PL= CONSULT\_W conservation officer response

**Subject:** F/21/24/PL

*Land rear of Waterbury House, Ford Road, Ford, BN18 0BH*

*Erection of 4 No supported living units (C3(b)), office block, car parking and associated works*

PROPOSED STREET ELEVATION

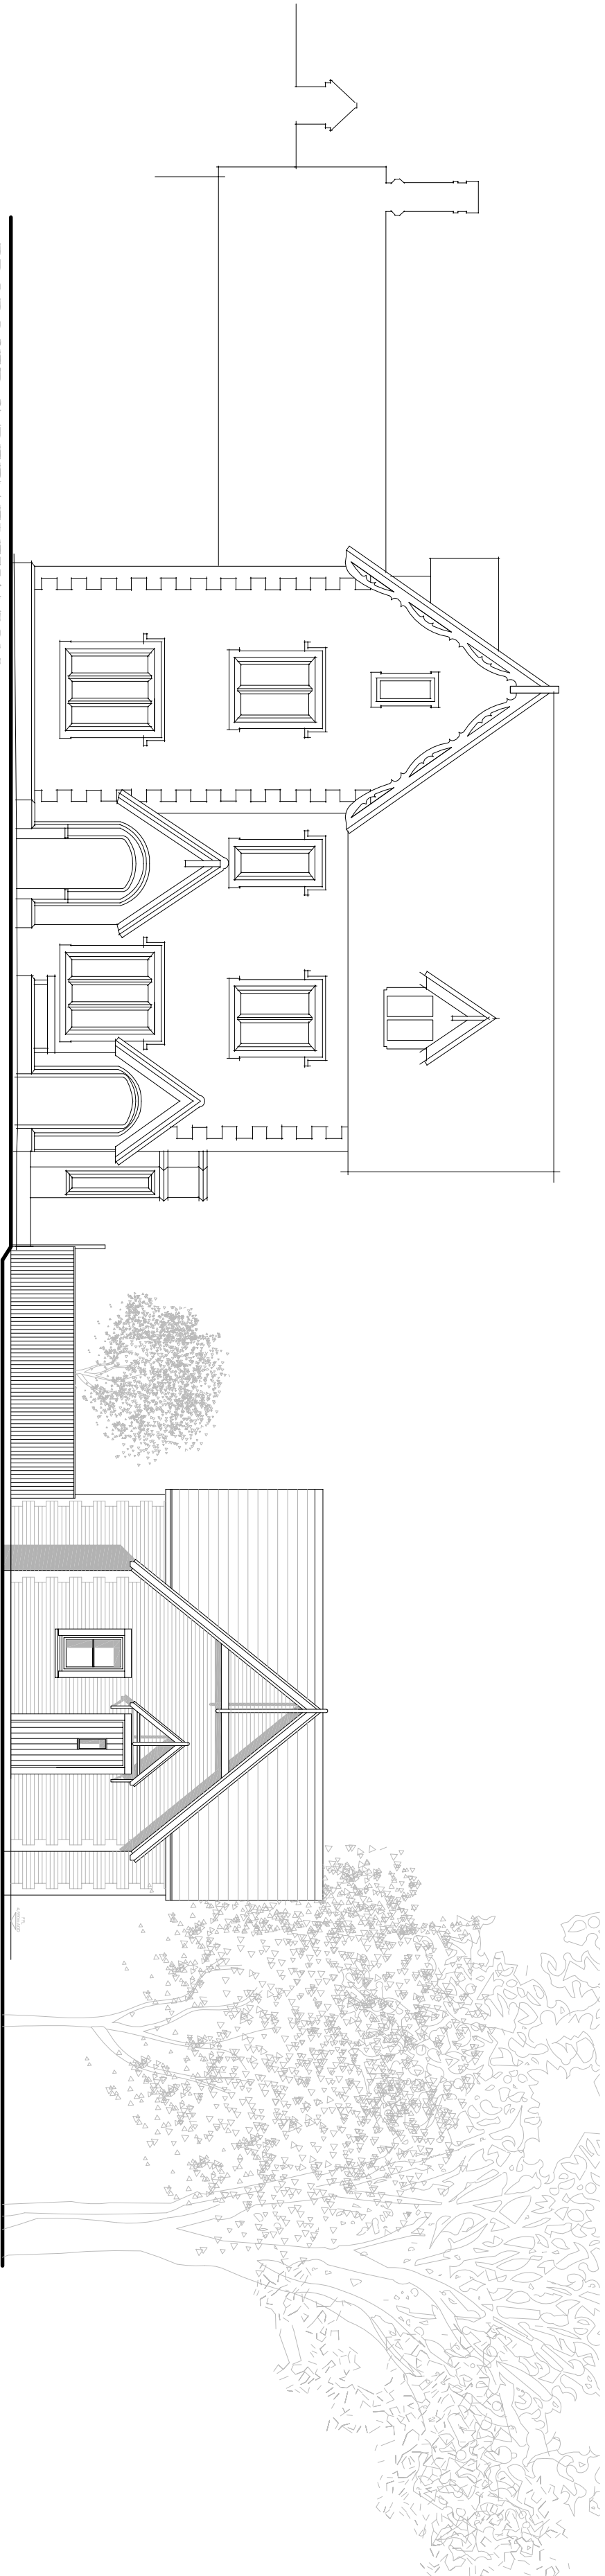
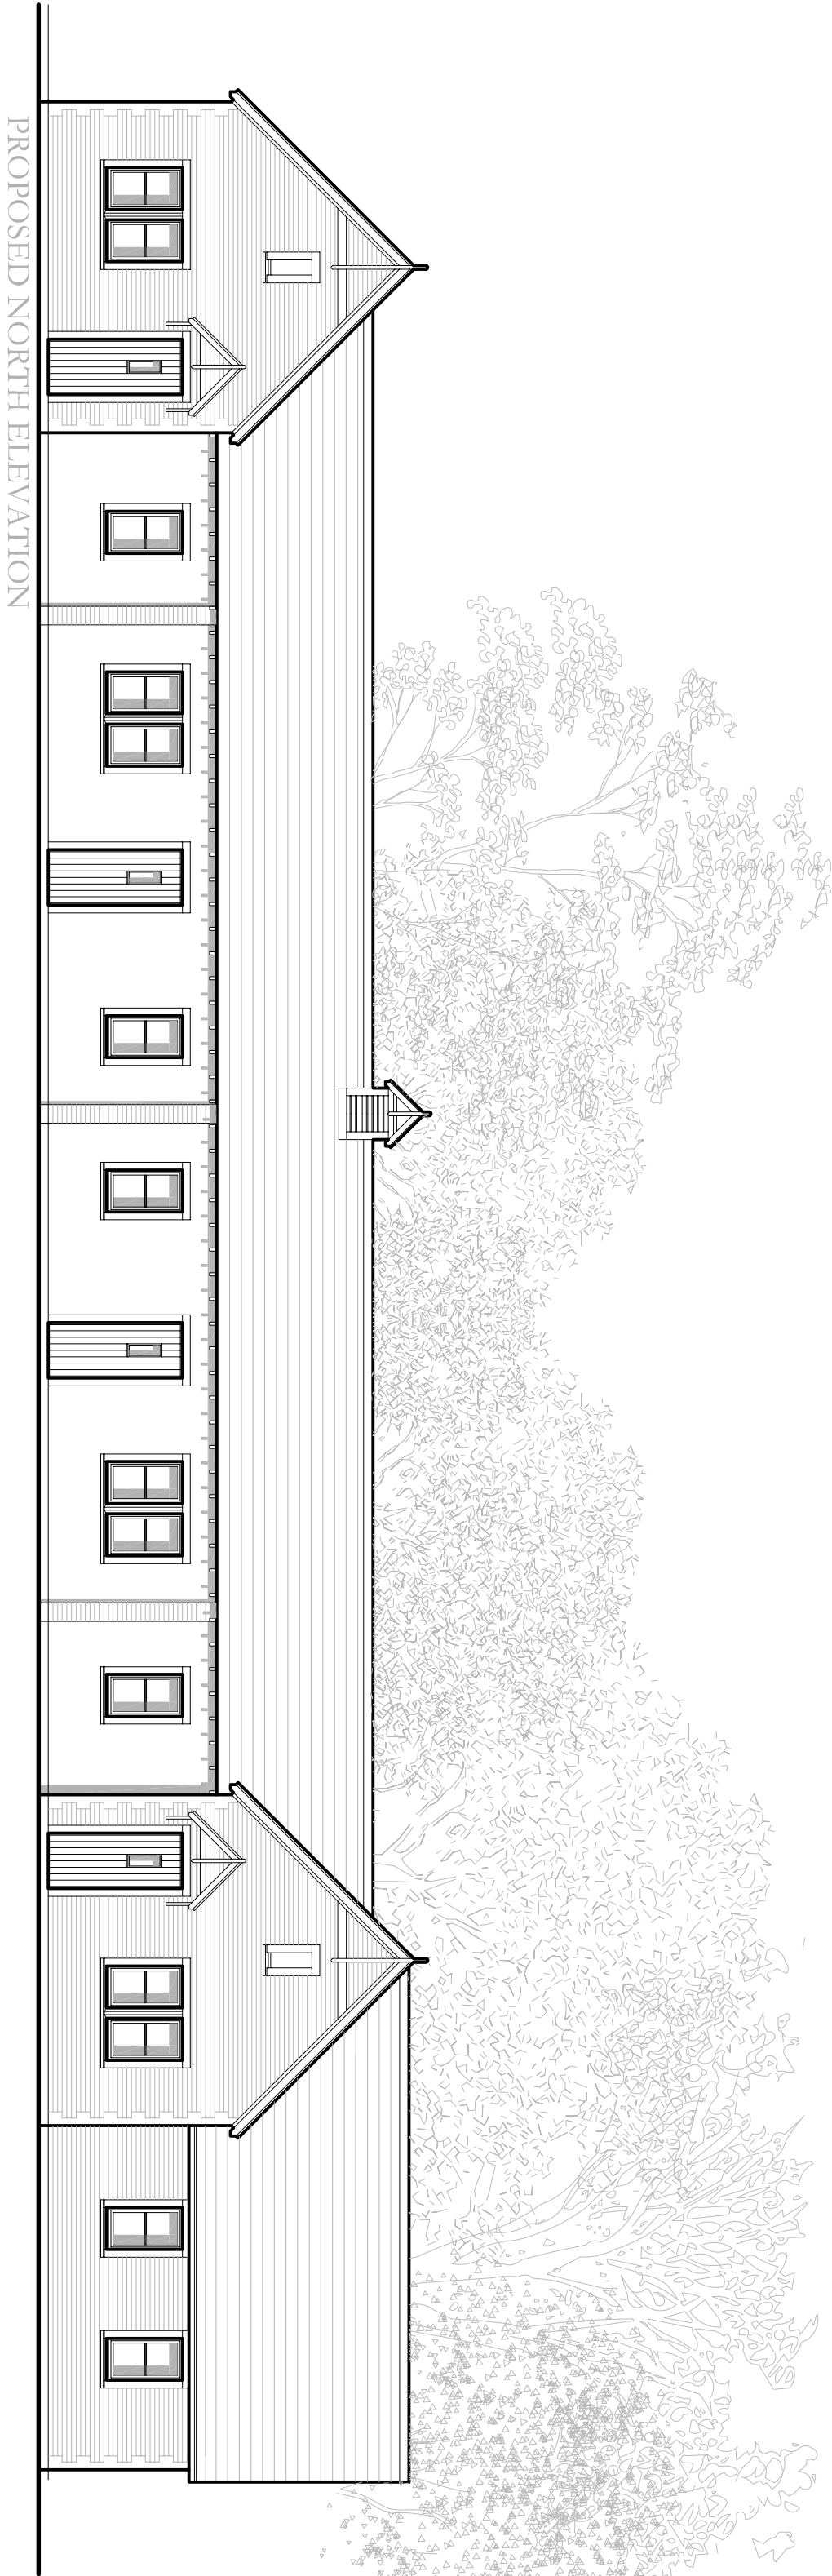
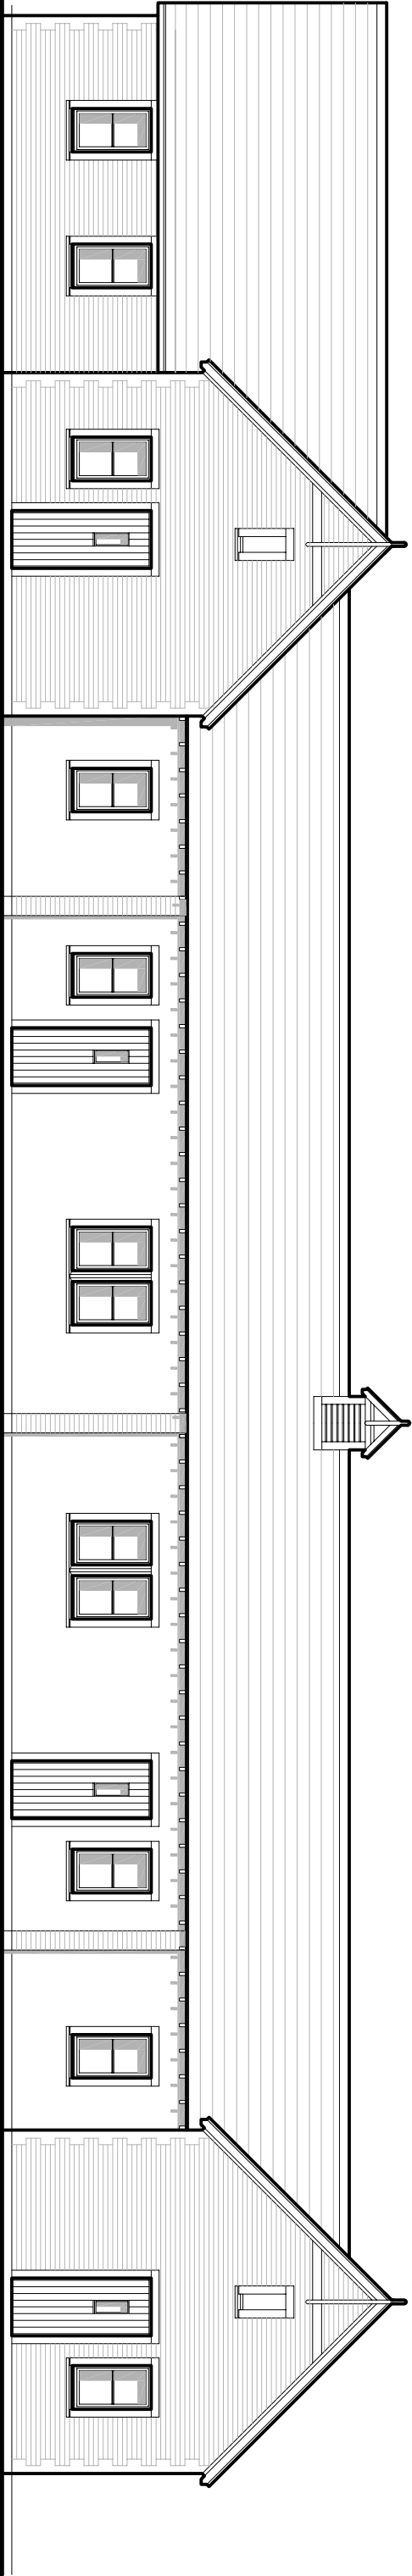
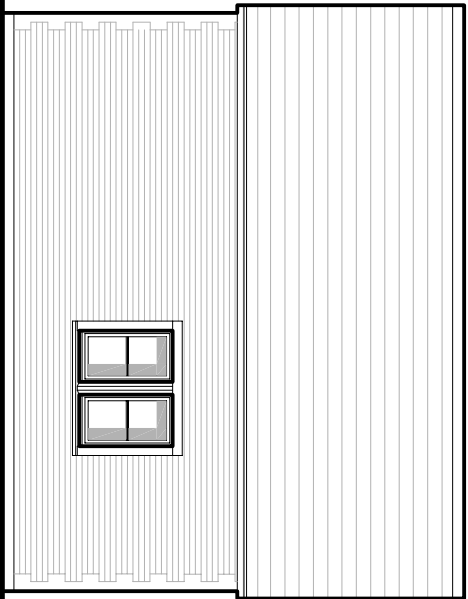
The listed building is primarily appreciated from the public highway, although it may also be visible from the adjacent railway line. The proposed structure is relatively low in height and appears subservient when viewed at the western elevation, aligning with a previously approved scheme. However, when viewed from the southern (and northern) elevations it is a substantial structure extending significantly into the curtilage. While this may not affect public views into the site, it will alter views from within the grounds of the listed building. The extent of this large form of new development within the grounds cannot therefore be said to have a neutral impact.

The proposed elevation treatment and roof form show a degree of architectural sympathy with the listed building, particularly on the western elevation. Such an approach is supported in principle. However, it is important to emphasise that the success of the scheme will depend significantly on the quality of materials, workmanship, and detailing - particularly elements such as the brick bond

The proposed material palette includes brick and render which are generally appropriate within the setting of a listed building. This is on the basis that they are of an appropriate quality. However, there is very little information provided regarding the windows, doors and other architectural details. These would need to be of an appropriate quality and detail (and position within the opening). Additional information regarding materials and detailing could be secured by condition, should the application be deemed acceptable.

*Prior to their insertion details of the windows and doors including their design/appearance (including elevation), specification, glazing bars, glazing (system), method of opening, decorative/protective finish (i.e. stain/paint and colour) and location within the reveal, in the form of drawings and sections of an appropriate scale, shall be submitted to and agreed in writing by the Local Planning Authority (via the relevant application form) before the windows and doors are installed.*

*No development shall take place until a 1 square meter sample panel of brickwork has been constructed on the site. This section will be inspected by the Local Planning Authority's Conservation Officer and photographic evidence of the sample panel including details of the brick, brick bond and mortar mix will be submitted to and approved in writing by the Local Planning Authority (via the relevant application form). Once approved, the work can proceed and the details so approved will be used within the construction of the development.*

PROJECT	WATERBURY GARDENS - FORD
DESIGNER	ASH
PROPOSED SITE PLAN	
DATE	14/02/24
REF. NO.	00072404
DRAWN/CHANGED BY	SP9
DESIGNER'S SIGNATURE	
REVISION

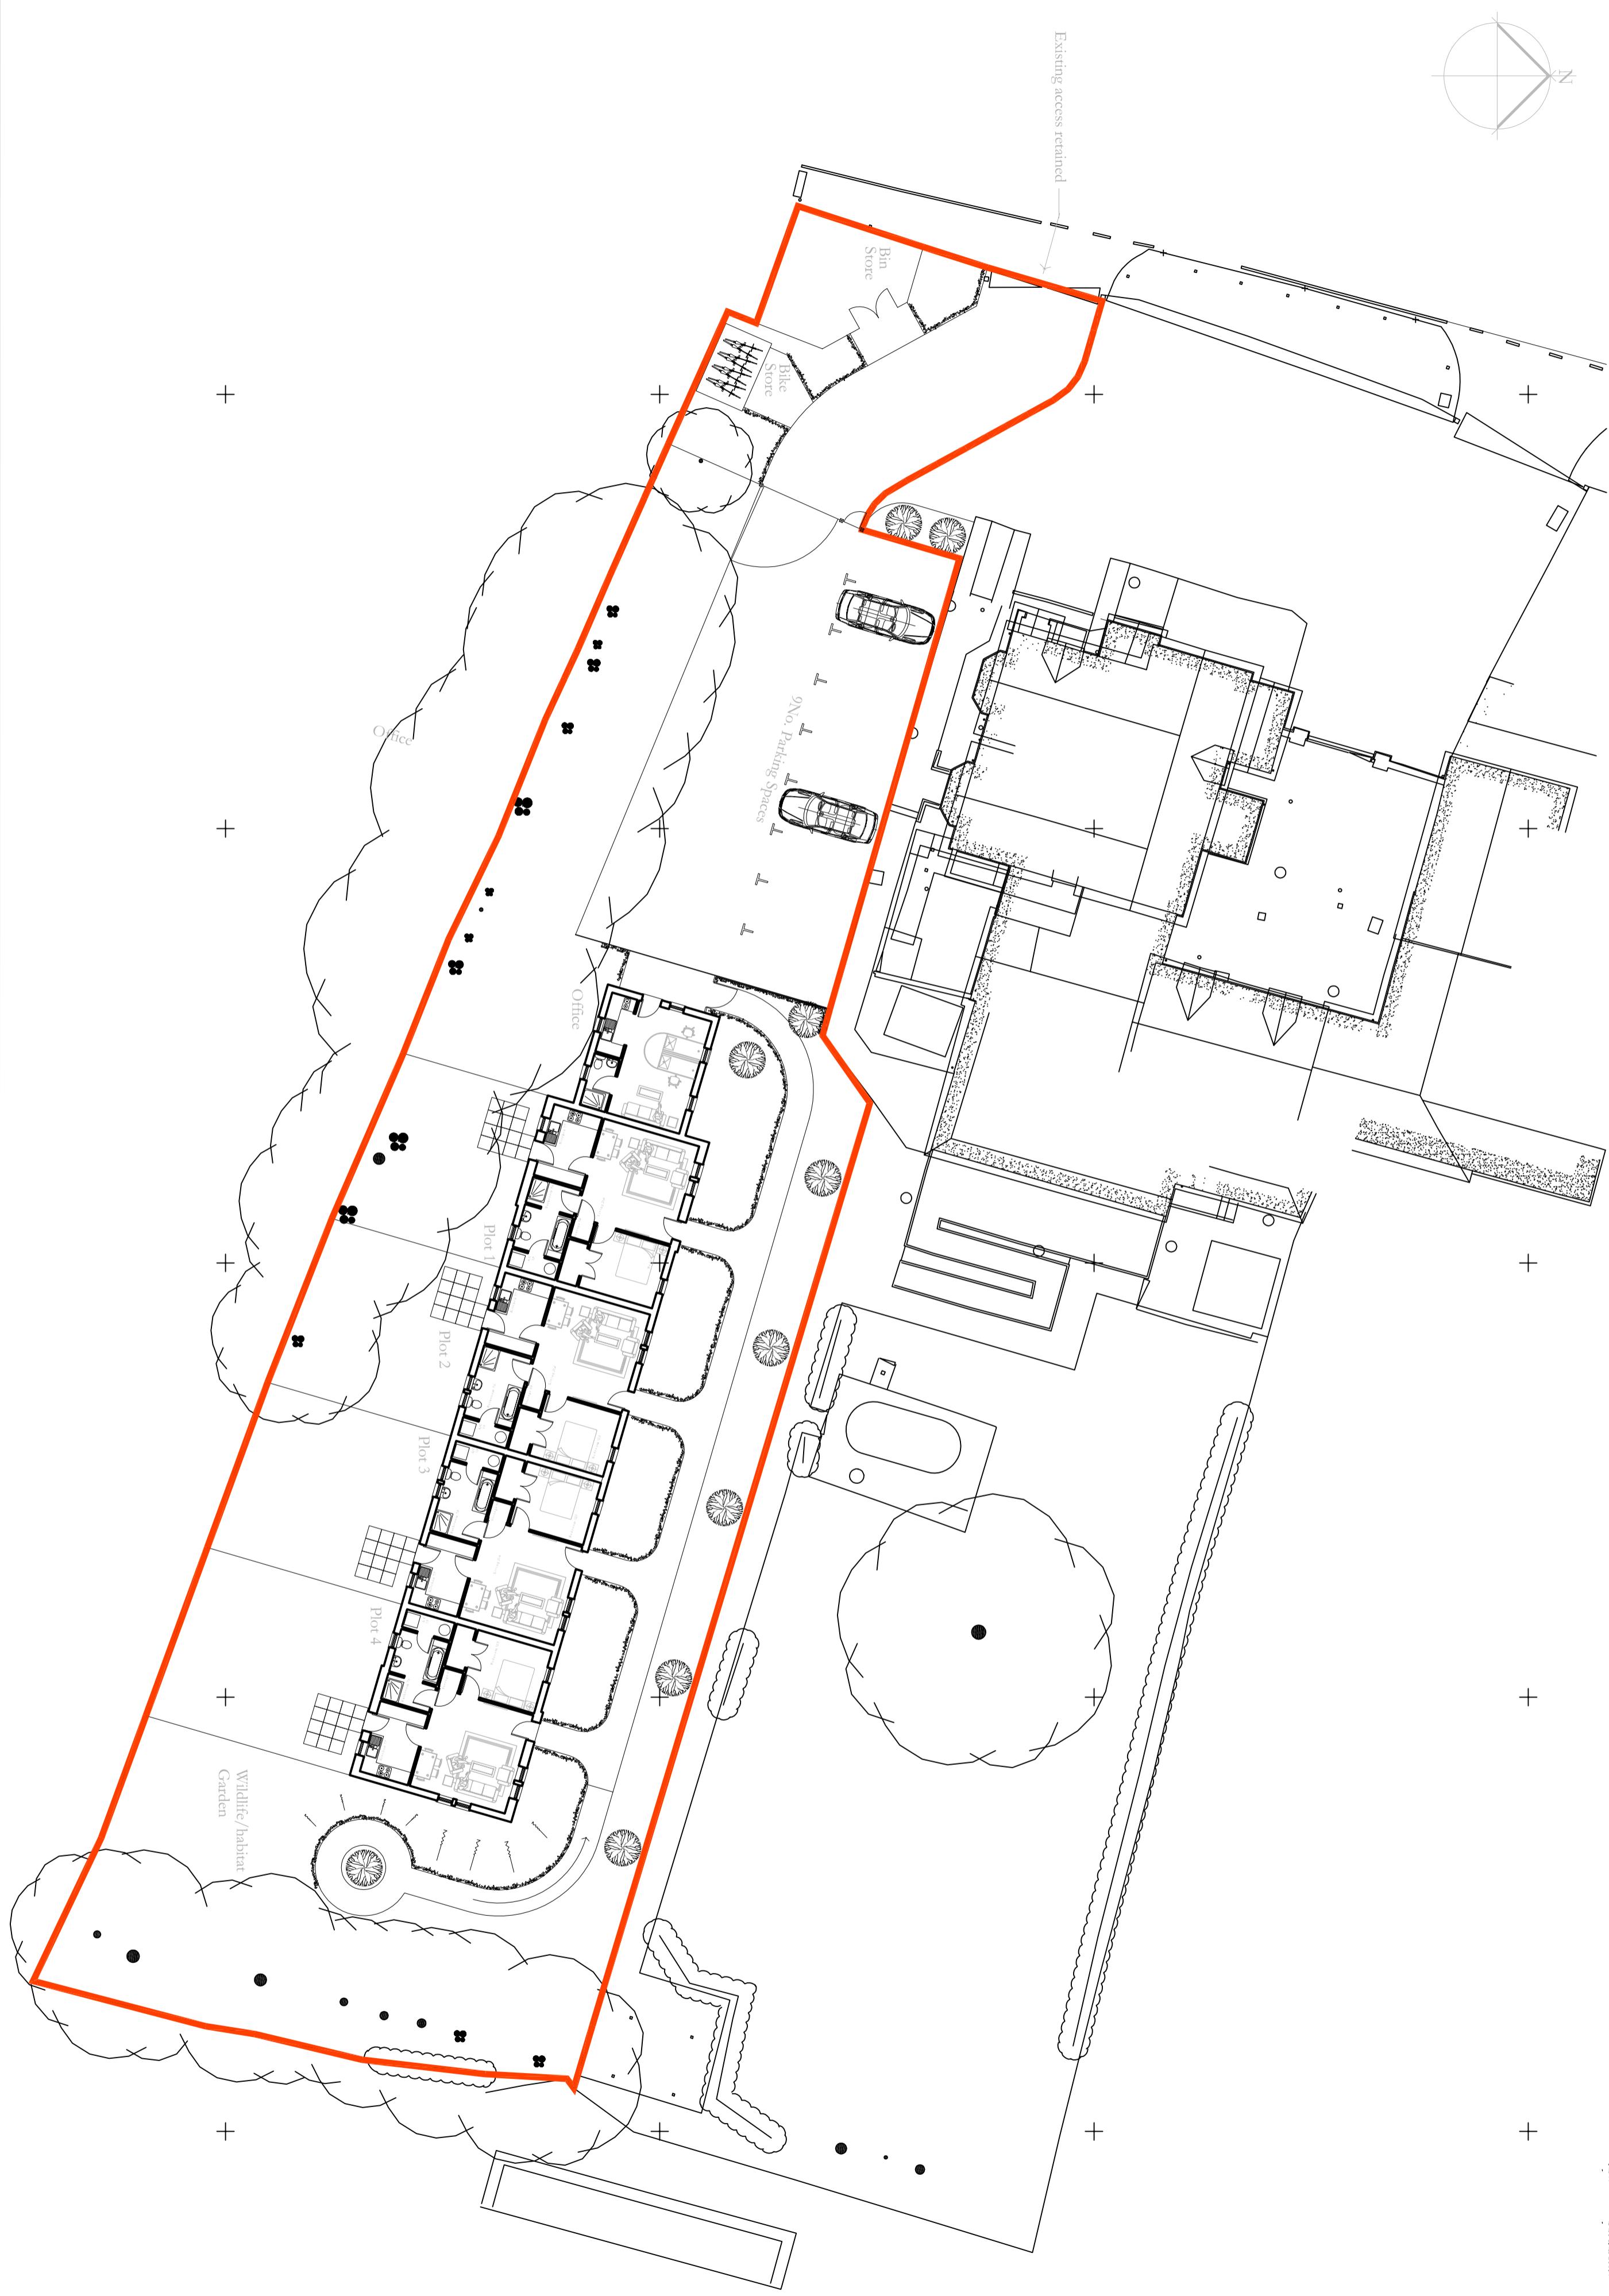
The landscaping strategy remains unclear. It is not evident whether the new building will be reintegrated into the existing grounds or remain separated by the current fencing. The latter approach risks further fragmentation of the curtilage and could negatively affect the setting of the listed building.

The proposed car parking area comprises a large expanse of hardstanding, which, combined with the presence of multiple vehicles, would dominate the southern elevation and result in the loss of the former garden area—albeit one that is currently neglected (although this can easily be rectified). Again, this is not necessarily a positive outcome. This area would require sensitive landscaping, including the use of mature planting, to screen parked vehicles and soften the impact on the listed building's setting.

Prior to first commencement of the development hereby permitted, a plan detailing the positions, height, design, materials and type of all proposed boundary treatments shall have been submitted to and approved in writing by the Local Planning Authority (via the relevant application form). The boundary treatments shall be provided in accordance with the approved details and shall thereafter be retained at all times.

Prior to the first occupation of any part of the development hereby permitted, full details of all hard and soft landscaping works shall have been submitted to and approved, in writing, by the Local Planning Authority (via the relevant application form).
